Cc: Jamey Ayling <jamey.ayling@co.kittitas.wa.us>; Bradley Gasawski <bradley.gasawski@co.kittitas.wa.us>; Zach Torrance-Smith <zach.torrancesmith@co.kittitas.wa.us>; Ellie Myers <ellie.myers@co.kittitas.wa.us>
Subject: SE-25-00014 Shamkhi - Notice of Application

RE: SE-25-00014 Shamkhi

TO: All Staff
FROM: Public Works Plan Review Team
DATE: September 24, 2025
SUBJECT: SE-25-00014 Shamkhi

SUBJECT: WDFW COMMENTS SE-25-00014 Shamkhi

HOLIDAY HILL PRELIMINARY DESIGN
MUNIR SHAMKHI
PRELIMINARY GRADING PLAN

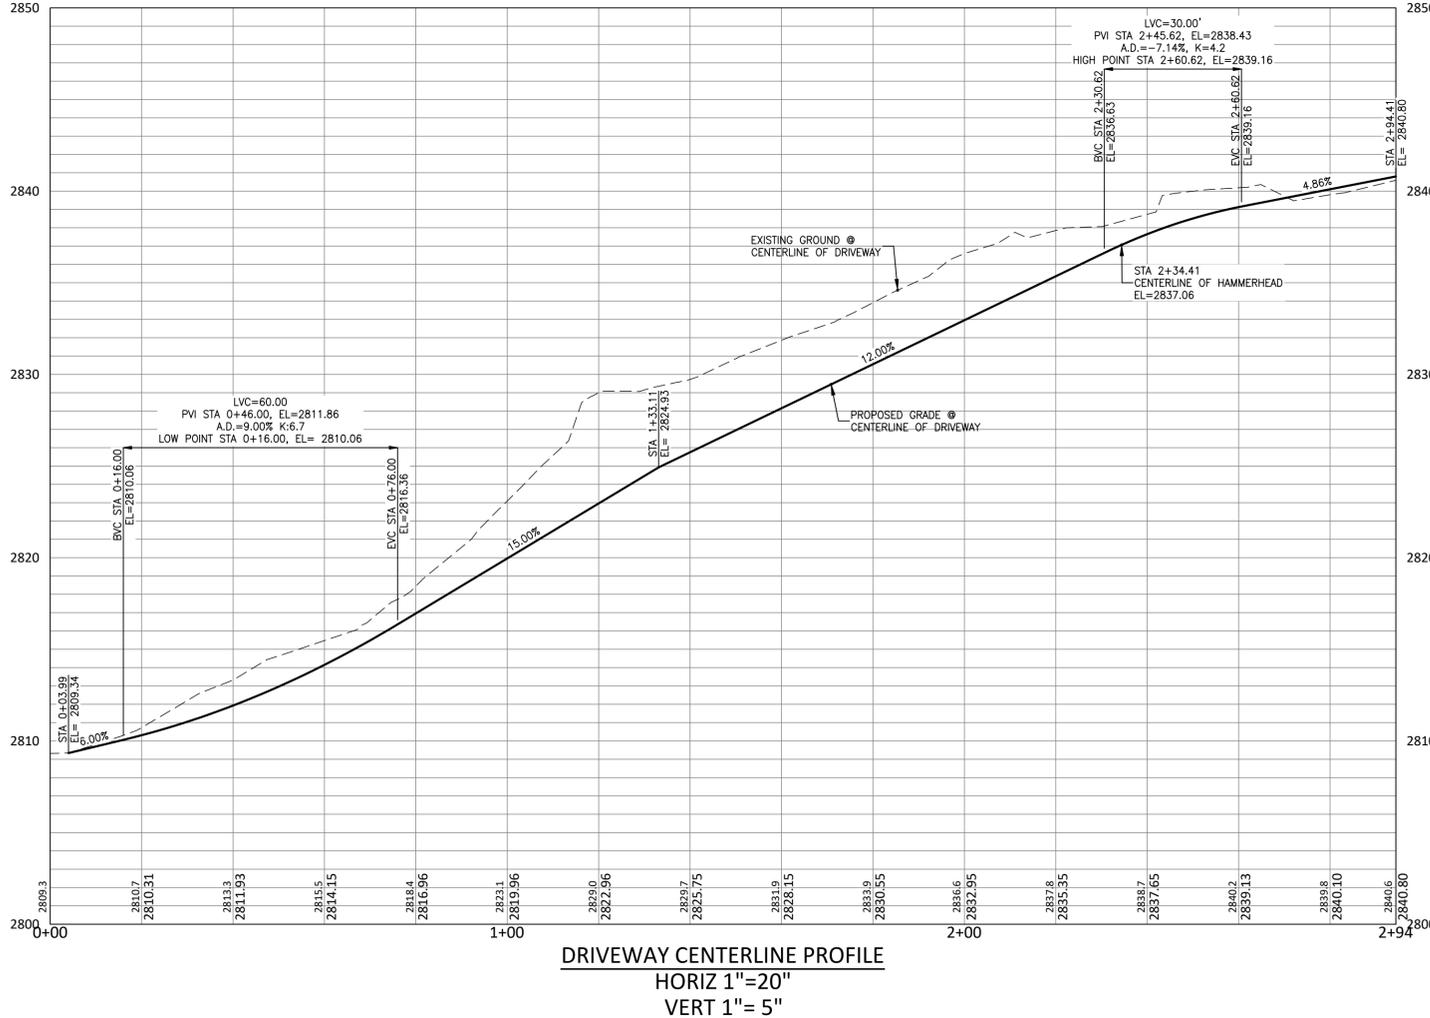
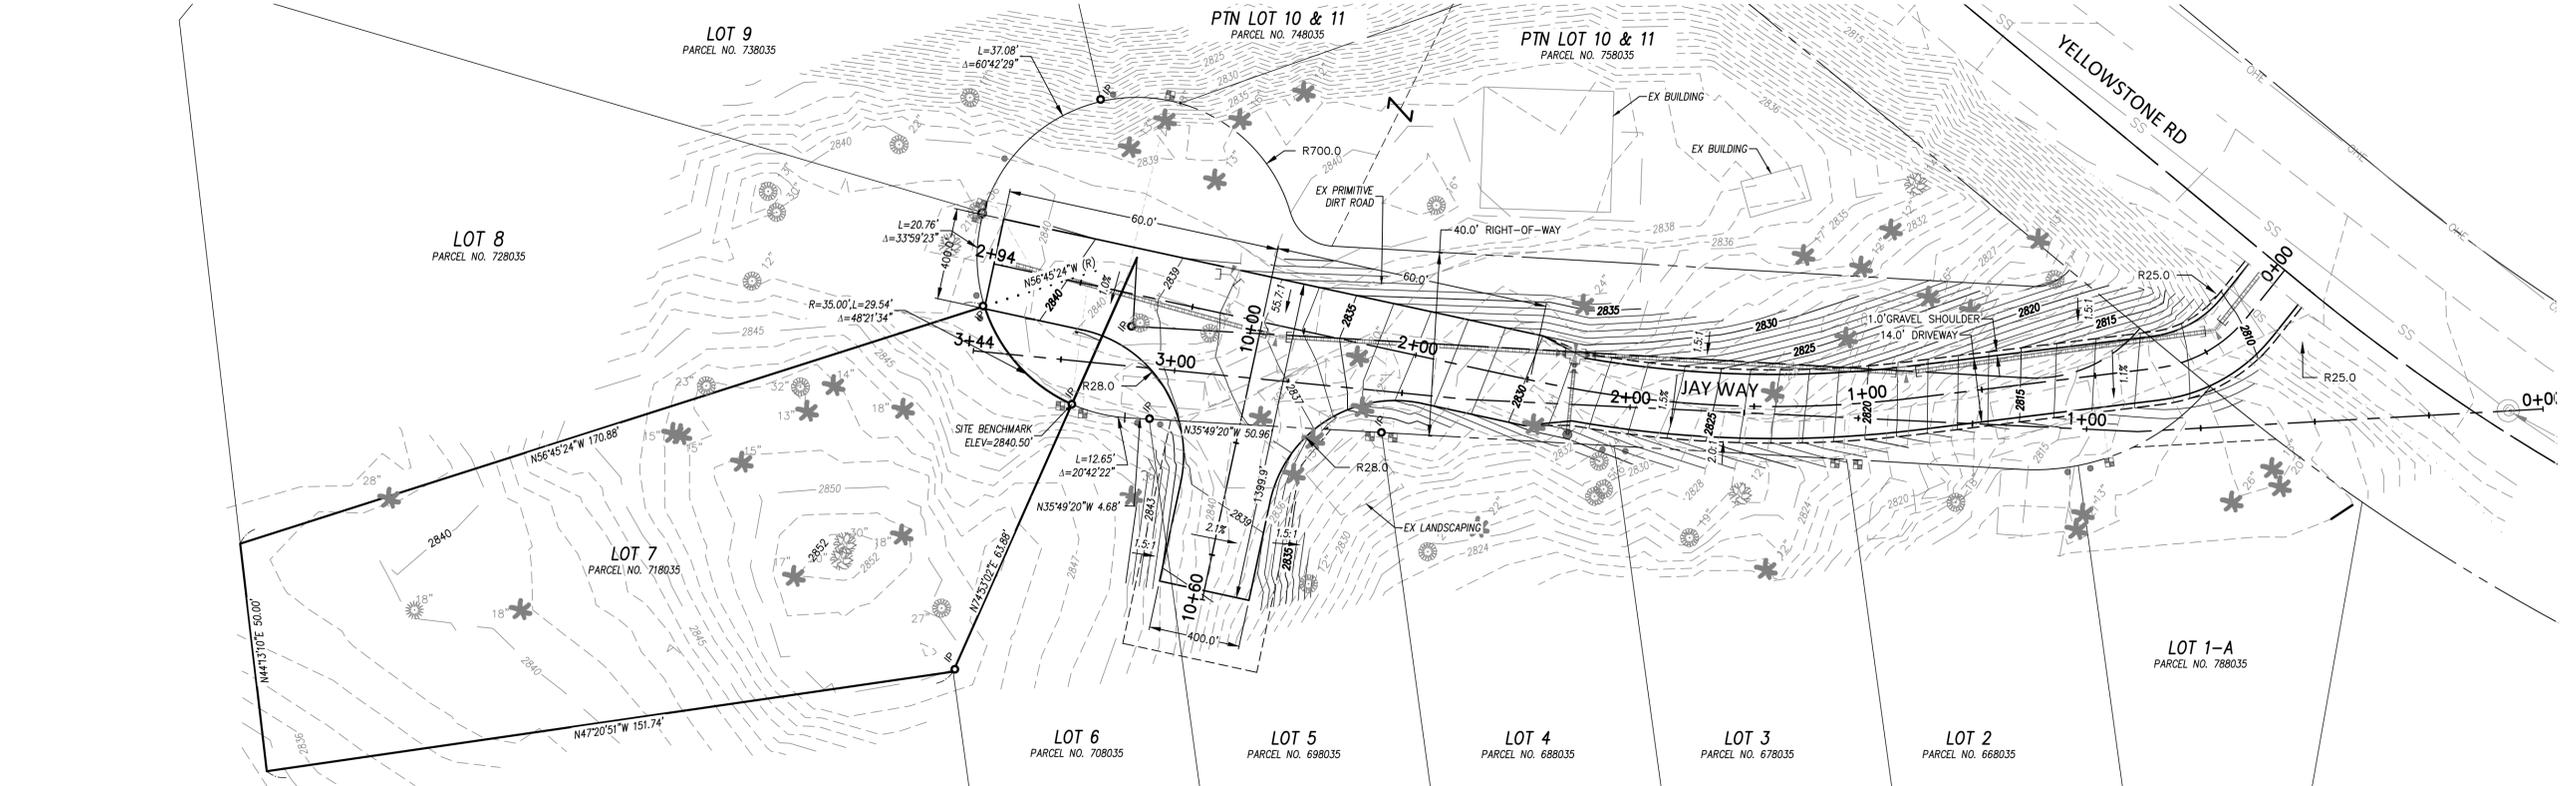
ENGINEERING	<p>A grading permit application has been submitted for this project (GP-24-00017) and comments have been sent to the applicant (as of the date of this comment 9/15/2025). Additionally, a stormwater report will be required if the grading is over 500 cubic yards.</p> <p>Per County Code 12.04.08.040 "Side slopes shall be constructed no steeper than two to one on both fill and cut slopes. Steeper slopes may be approved by the County Engineer upon review of a geotechnical investigation...". Please provide justification that a 1.5:1 (H:V) side slope will be stable. (CBP)</p>
SURVEY	<p>There are no survey comments regarding this application (JT).</p>
TRANSPORTATION CONCURRENCY	<p>No transportation concurrency requirement for this project. (KAH)</p>
FLOOD	<p>No comments. (SC)</p>

HOLIDAY HILL PRELIMINARY DESIGN
MUNIR SHAMKHI
PRELIMINARY SEWER PLAN & PROFILE

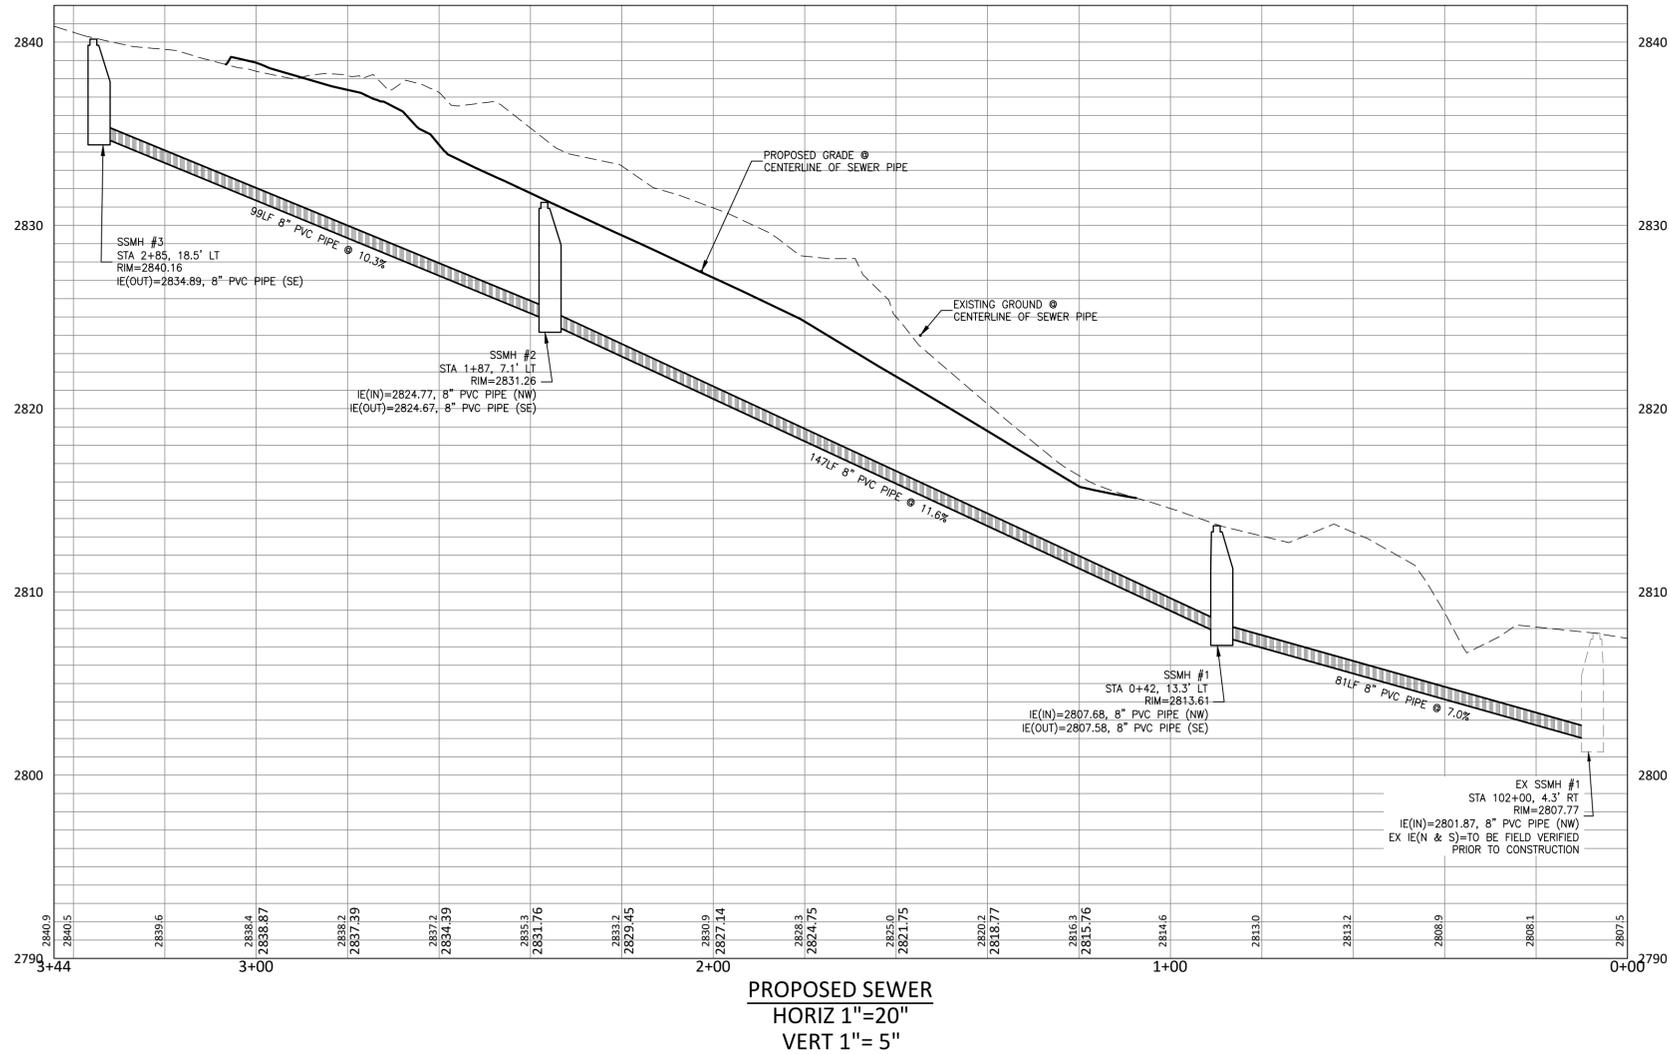
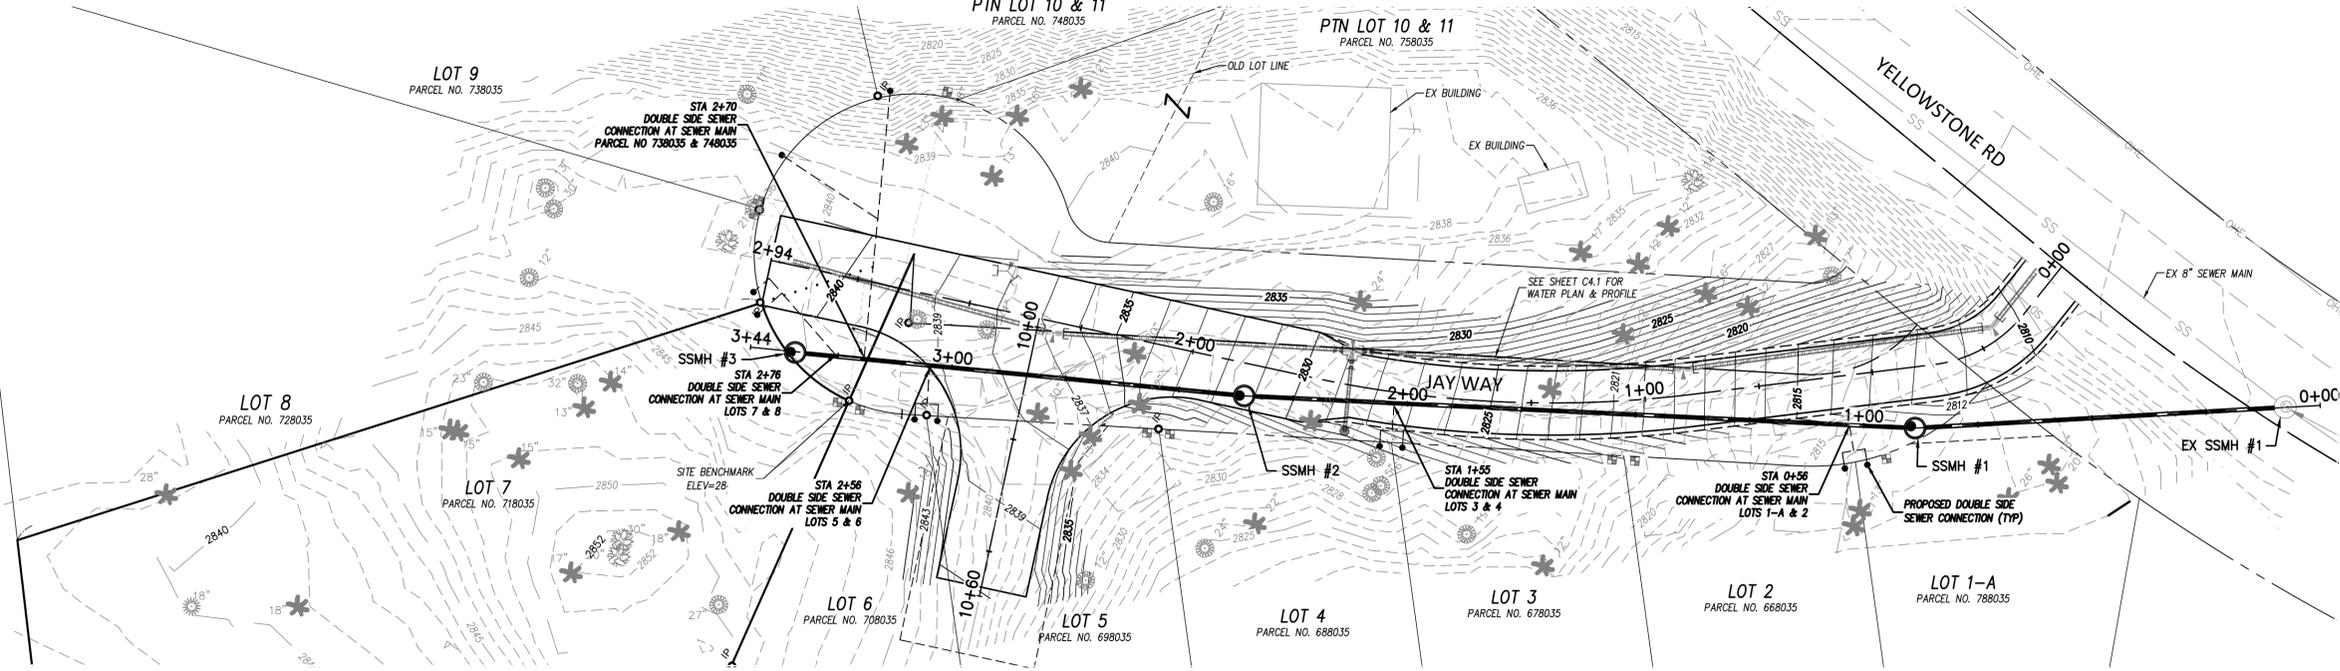
ACCESS	<p>It appears that PTN Lots 10 & 11 are part of this plat and utilize Jay Way to access said lots. If so, access will need to be maintained as part of this project. (CBP)</p> <p>A Private Road Access Application has been submitted for this project, and construction of the Apron for Jay Way(AC-24-00072)</p> <p>An Access Application has been submitted for a single-family residence (AA-24-00084) at 110 Jay Way</p> <ol style="list-style-type: none"> 1. An approved access permit shall be required from the Kittitas County Department of Public Works prior to creating any new driveway access or altering an existing access. 2. Maintenance of driveway approaches shall be the responsibility of the owner whose property they serve. The County will not maintain accesses. <p>In addition to the above-mentioned conditions, all applicable Kittitas County Road Standards apply to this proposal. Access is not guaranteed to any existing or created parcel on this application. (RC)</p>

HOLIDAY HILL PRELIMINARY DESIGN
MUNIR SHAMKHI
PRELIMINARY WATER PLAN & PROFILE

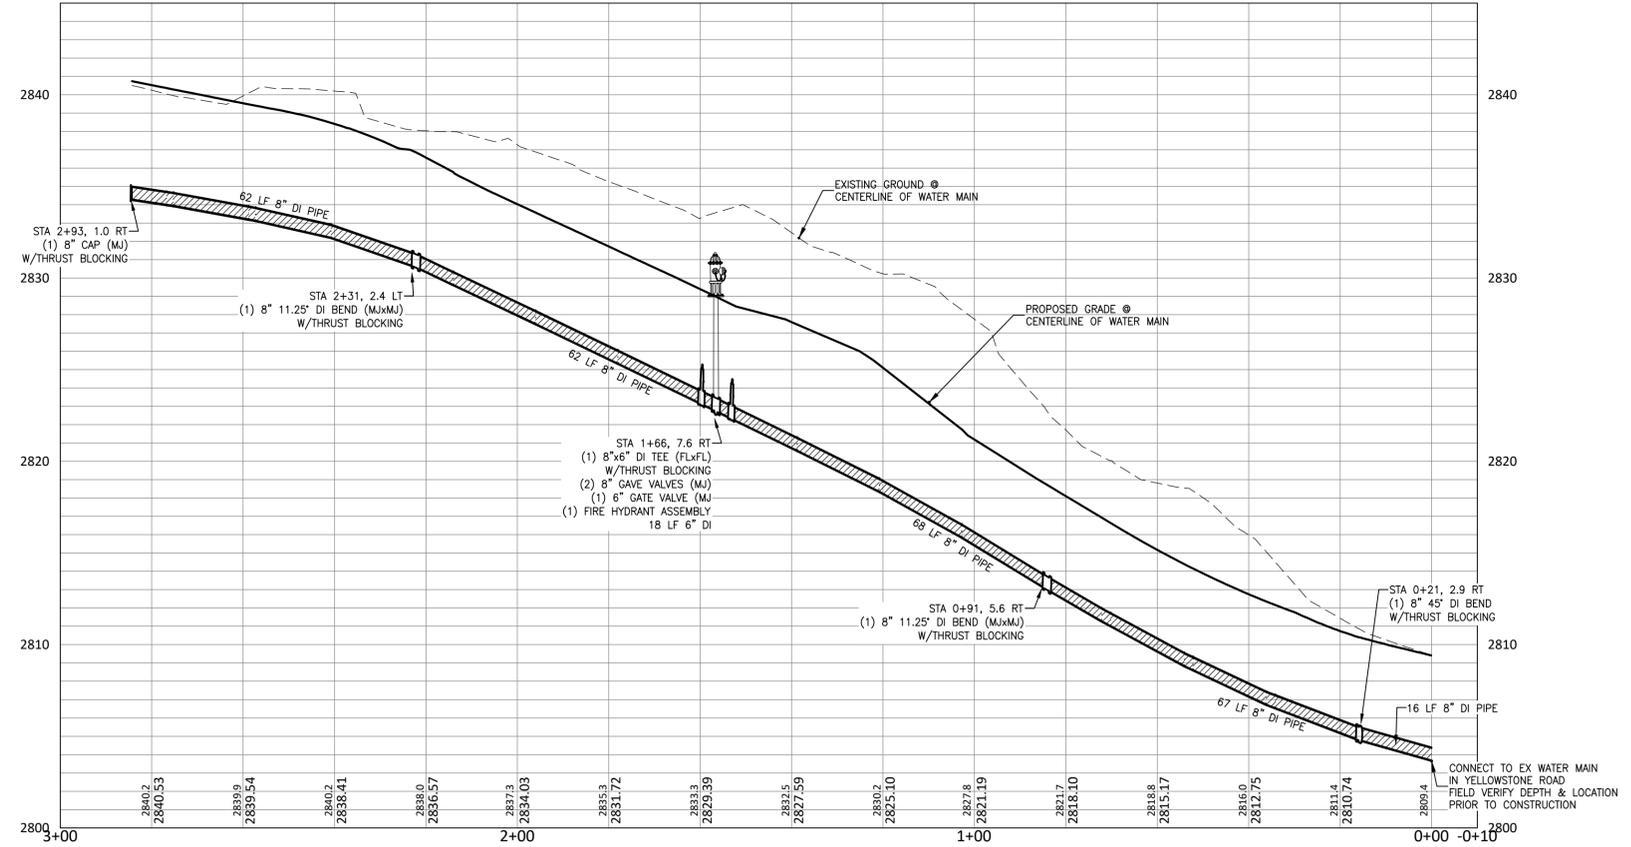
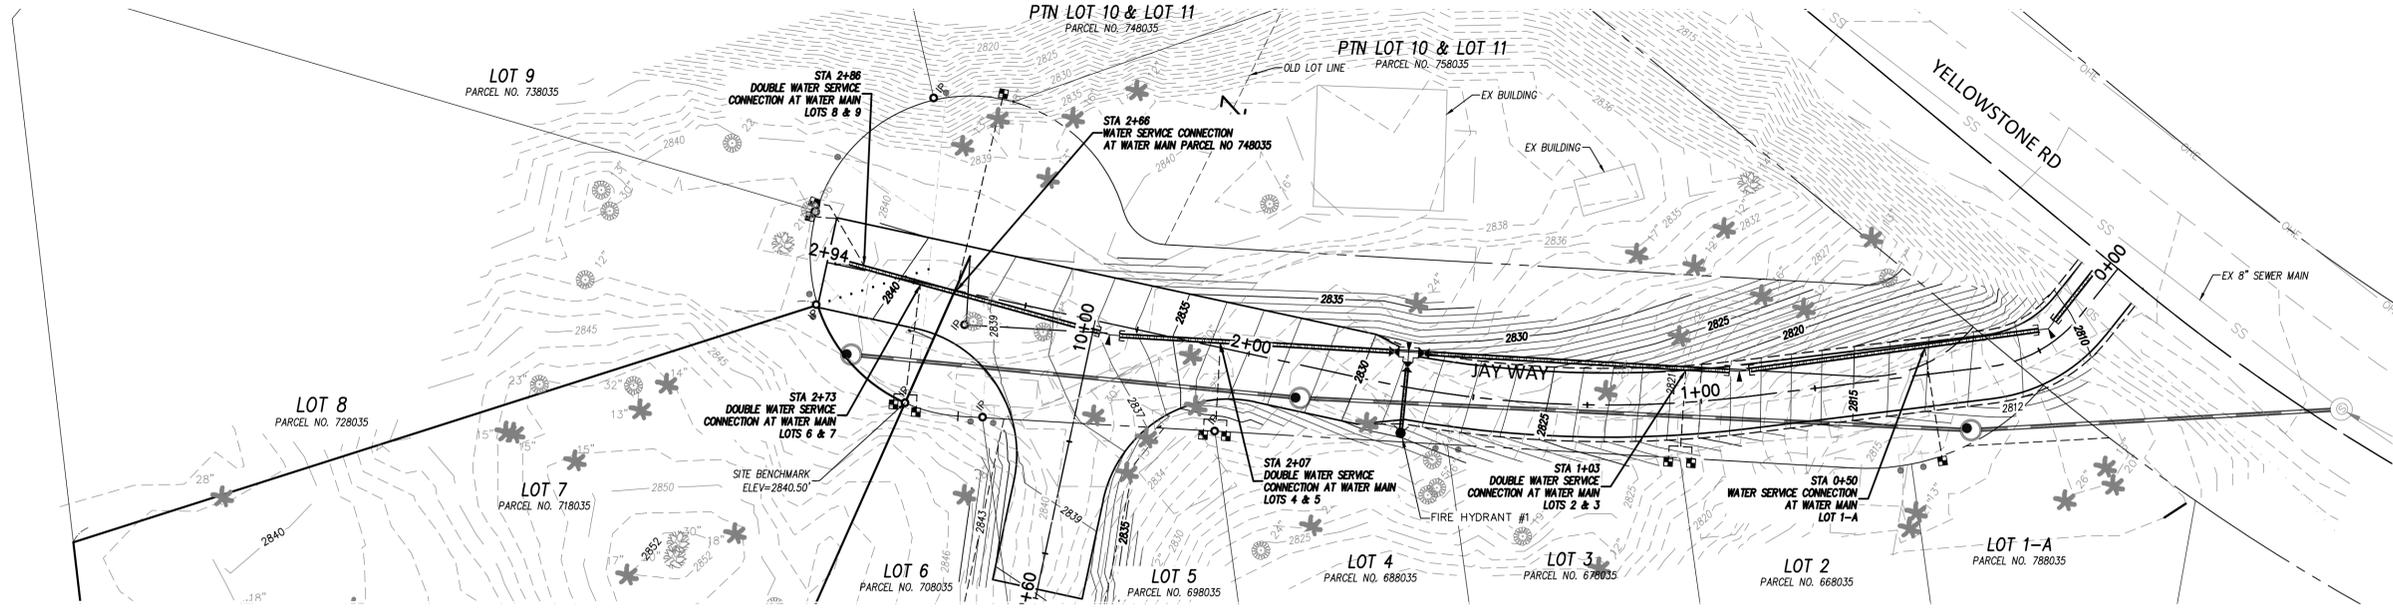
1. Is the applicant's property served by a public water system? DOH sees reference to both "West Water" (a now inactive public water system because of consolidation into another public water system) and Snoqualmie Pass water system that is an active water system.
2. DOH ODW will have additional comments if the response to the above comment is "yes".

1. The proposed development represents two (2) connections: the home and the ADU.
2. The Snoqualmie Pass Utility District (81048F) has capacity to serve these additional connections.
3. Due to DOH ODW operations, the Snoqualmie Pass Utility District is managed through the DOH ODW Engineer assigned to King County (Brietta Carter, who is Cc'd on this email). Any additional comments will be provided by Brietta.
